Blayney Shire Council
Comments and Recommended Conditions of Consent SSD 6594

Clarifications

Conceptual Development Layout
FIGURE 3

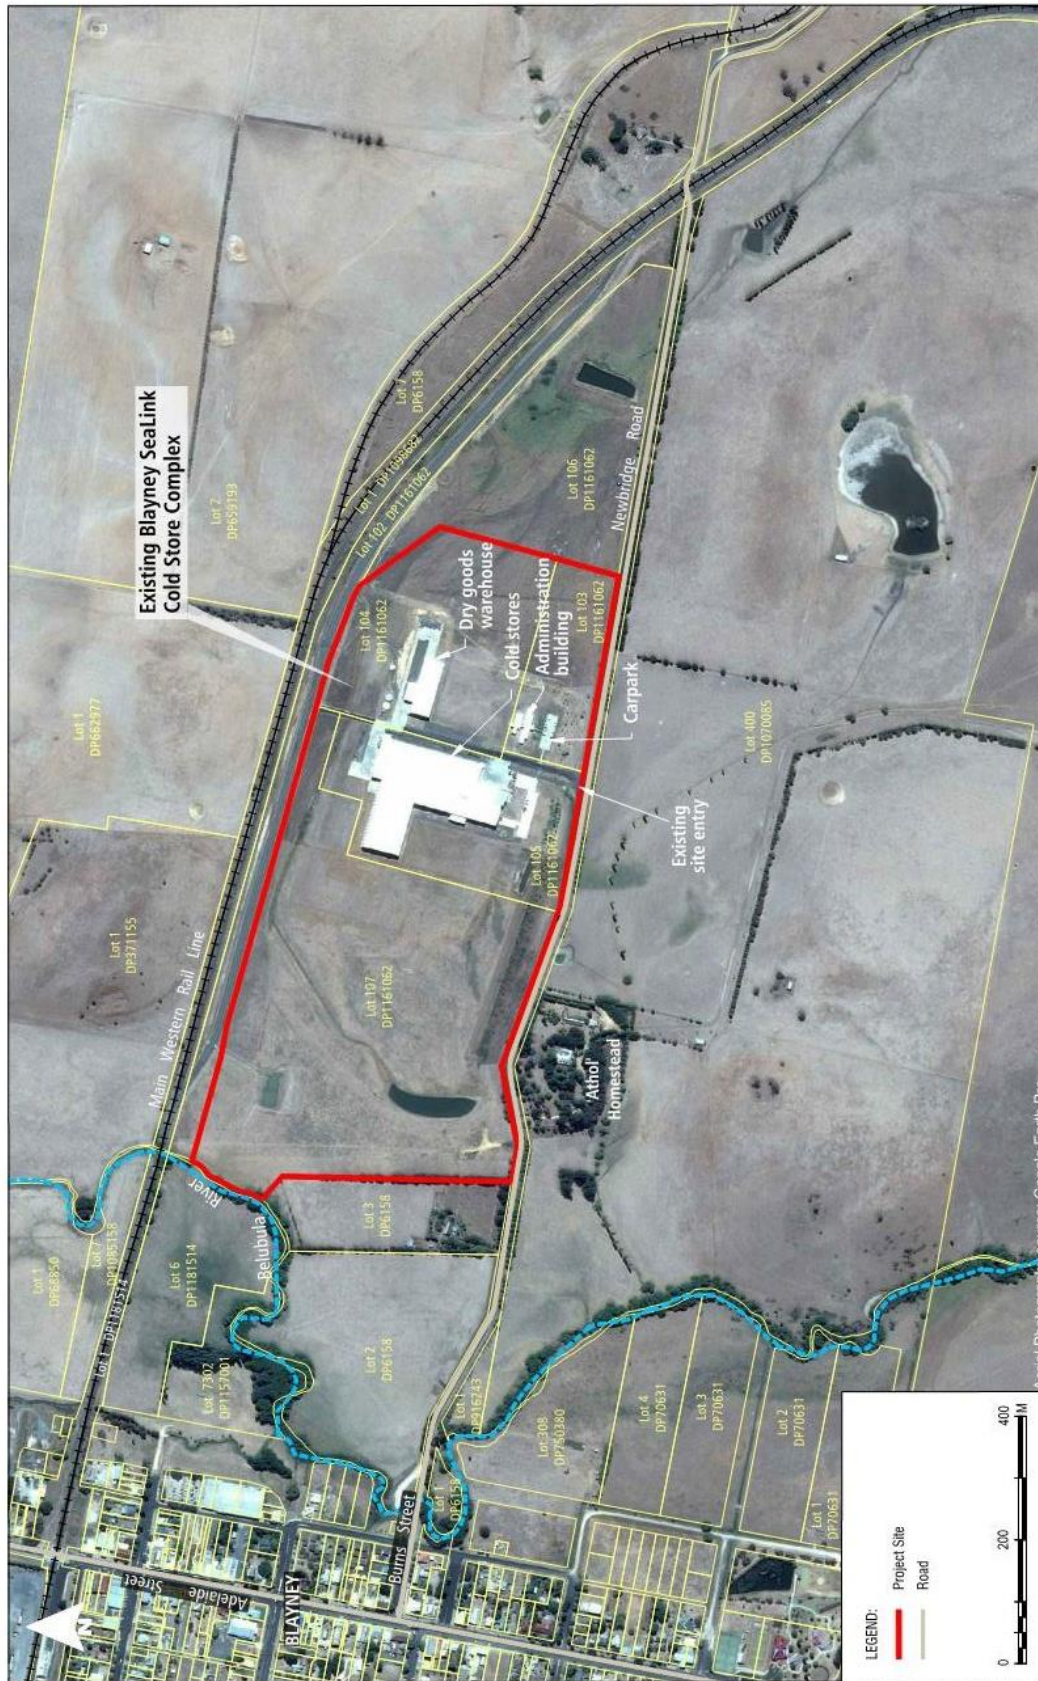
3. On page 13 of the EIS zone IN2 General Industrial is referenced. It may have meant to be IN1 General Industrial.
4. The concept drawings on page 27 of the EIS show that the unloading dock as not being fully enclosed. Council requires confirmation that the unloading dock will be fully enclosed including automated roller door.

- a. Australian Native Landscapes - Approximately 8.5 kilometres away
 - b. Nestle Purina – Approximately 2.2 kilometres away
6. Council would like to confirm that the “yard pens” shown on page 27 of the EIS will be constructed of a concrete floor?

Figure 10: Concept Landscape Plan

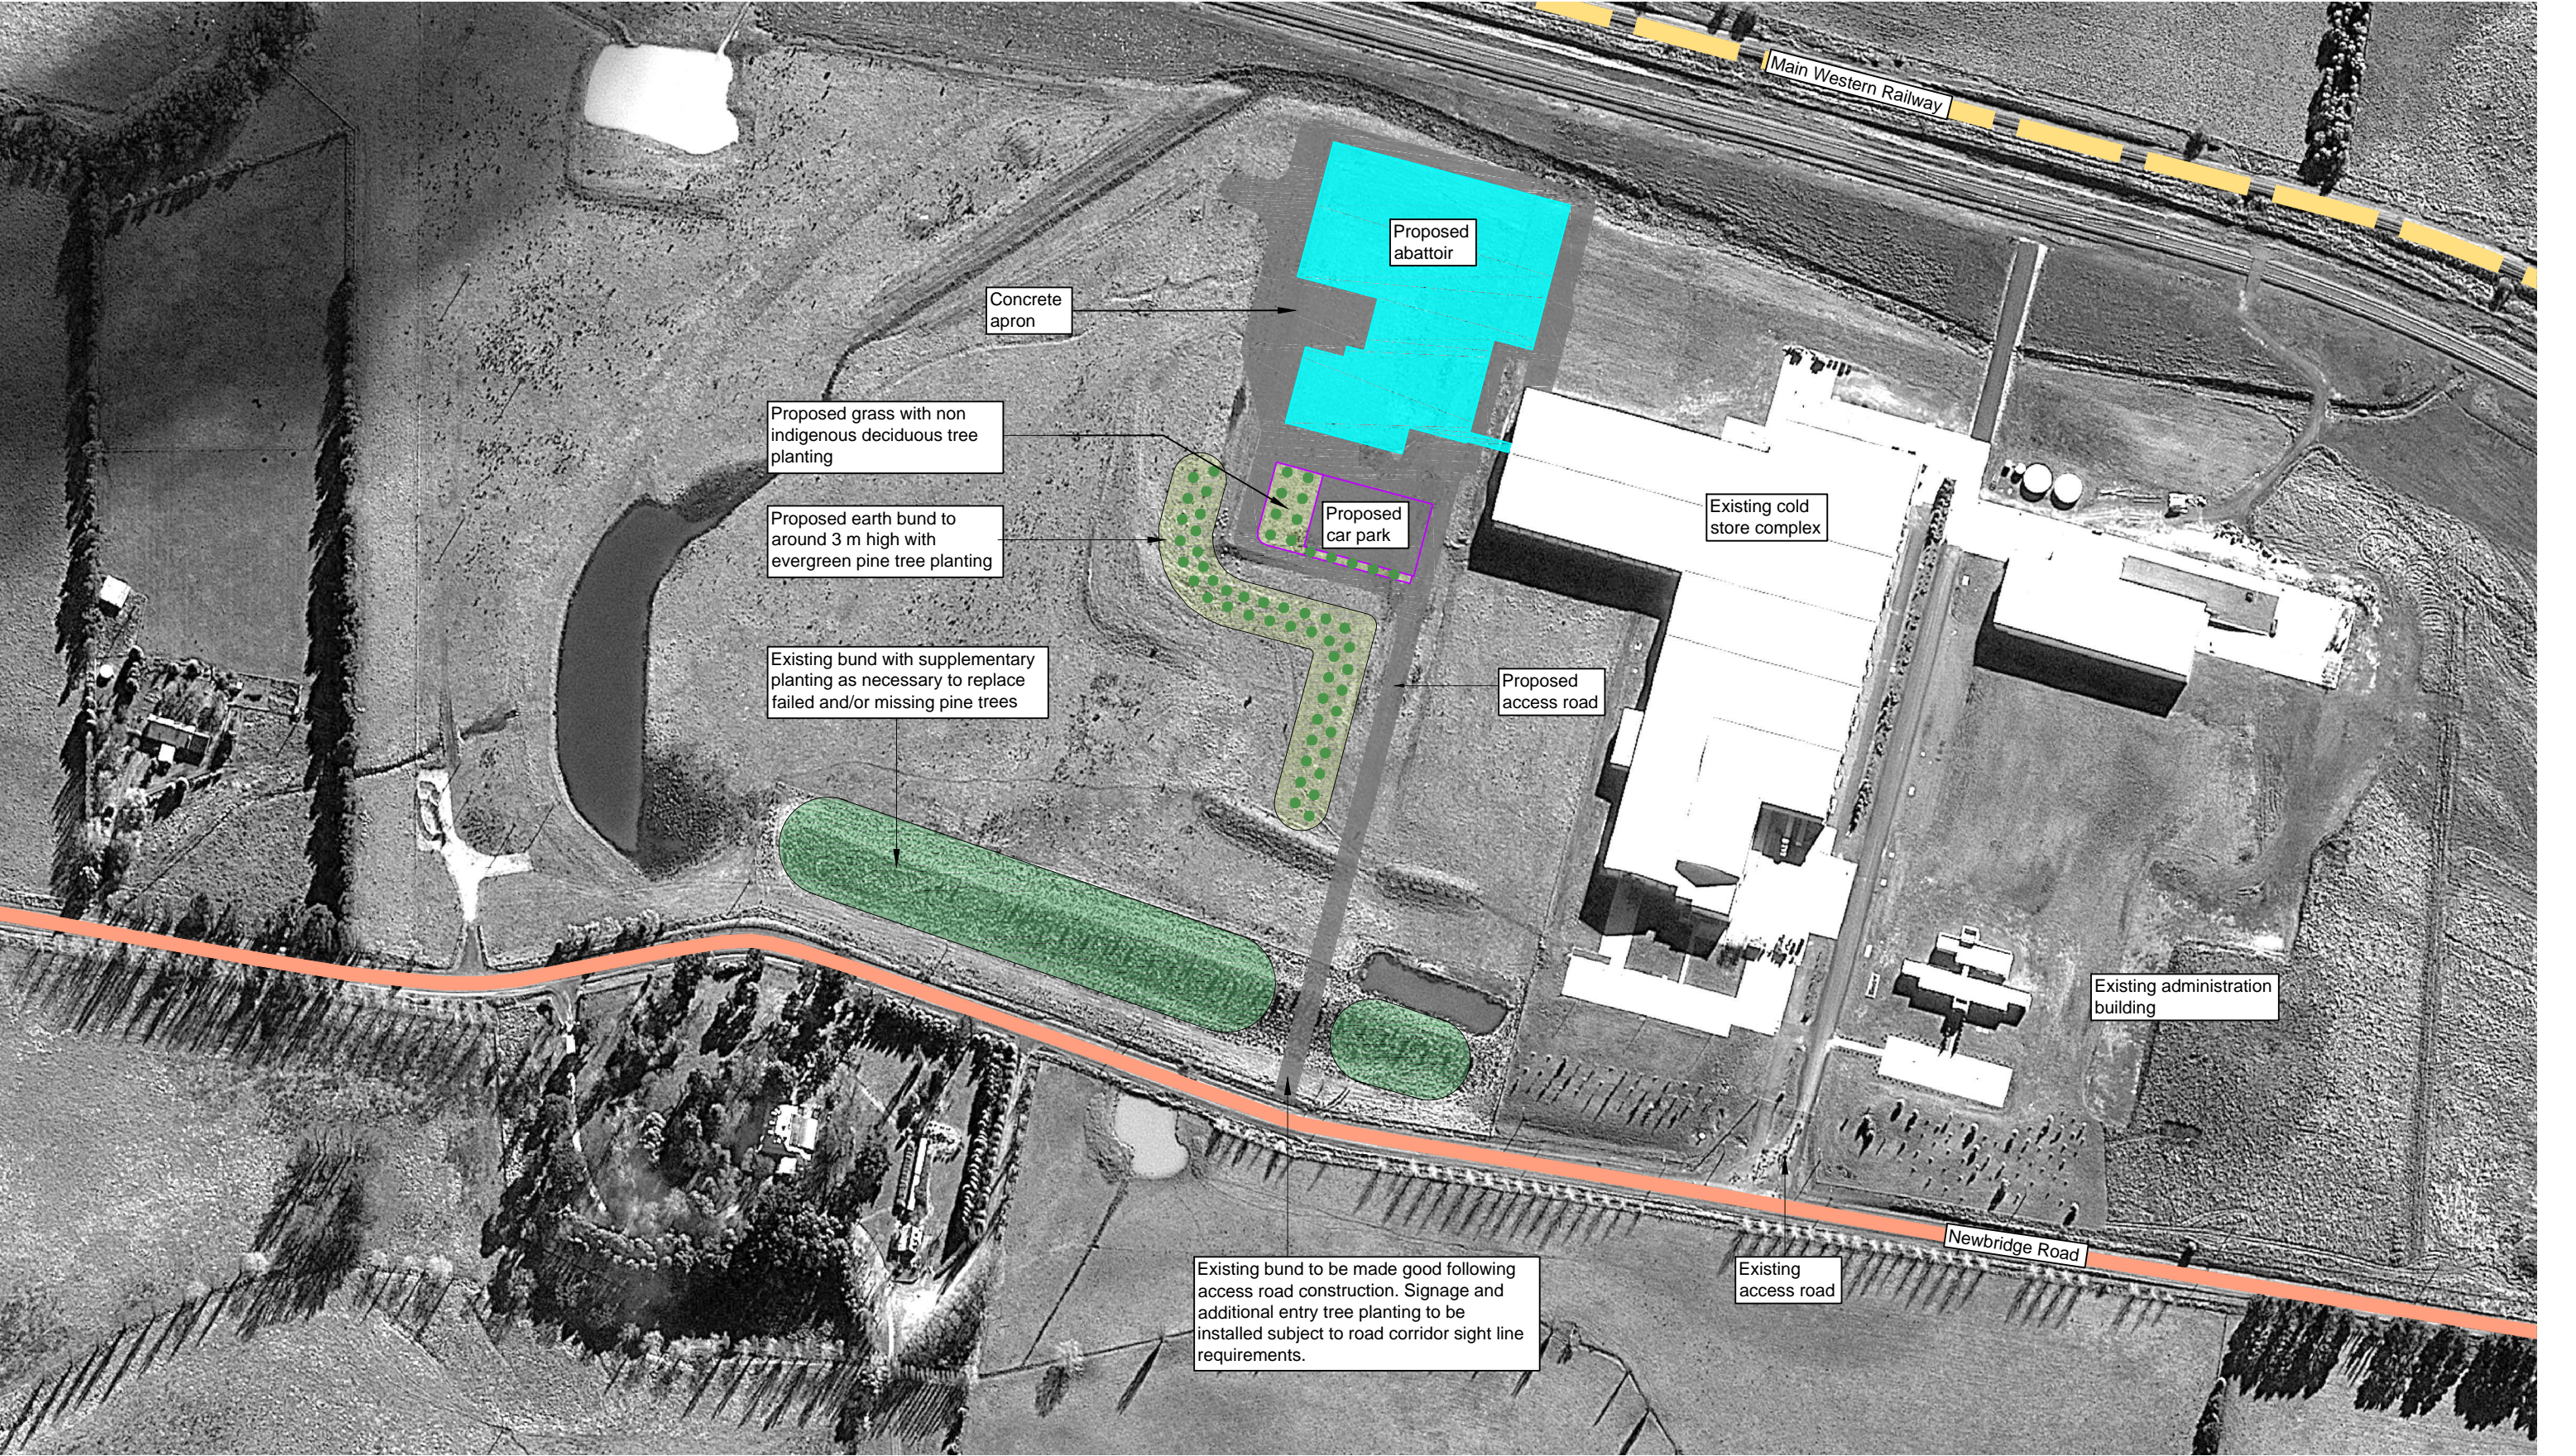
The landscaping plan on page 116 of the EIS does not appear to identify landscaping to screen the entire western façade of the proposed abattoir.

Council requests that landscaping is incorporated to screen the western façade of the proposed abattoir.
